From: Simon Davis <Simon.Davis@arun.gov.uk>
Sent: 27 July 2020 11:01
To: Planning.Responses <Planning.Responses@arun.gov.uk>
Subject: FW: AL/46/20/PL Wings Nursery

App No: AL/46/20/PL
Address: Wings Nursery Lidsey Road Woodgate PO20 3SU
Address: Demolition of Wings House & the erection of 81 No. replacement dwellings (80 net new dwellings), access arrangements, sustainable drainage measures, public open space, landscaping & all other associated works. This application is a Departure from the Development Plan.

Bats

T7, a large mature oak tree with multiple suitable features for roosting bats. View looking east.

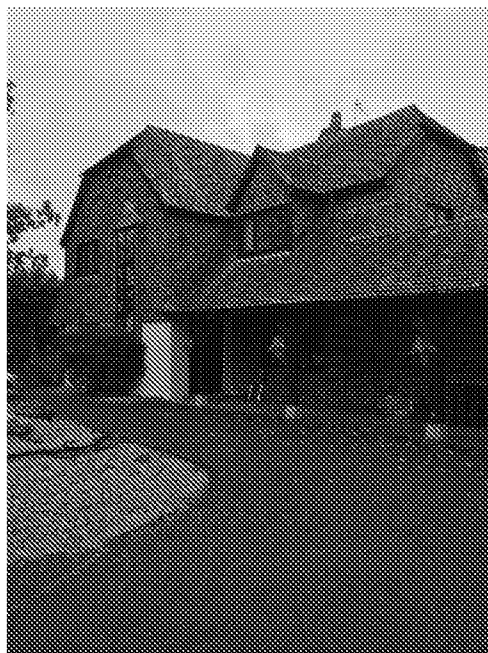
Please see attached further ecology comments. As you will see, we require prior to determination the submission of a mitigation strategy detailing the timings of the works, temporary roosting sites, methodology of the works, roost restoration post development and post development monitoring and safeguarding. It would be helpful and tie everything together if this also covered the precautionary approach to Tree T7.

As detailed within the Bat Survey Report (July 2020) a precautionary approach should be undertaken for the felling of T7. Felling or remedial works should avoid the hibernation season (mid November to mid-March inclusive), with trees to be section felled avoiding any visible cavities, sections (but not brash) to be left for a minimum 24hrs on the ground before chipping or removing from site. If a bat is found all works must stop and Natural England consulted.

In terms of tree T7 – the ecologist's tree references differ to the arboricultural report, so T7 is actually T15 in the arboricultural report. T15 will be retained, therefore no recommendations regarding felling apply. Apologies for any confusion.
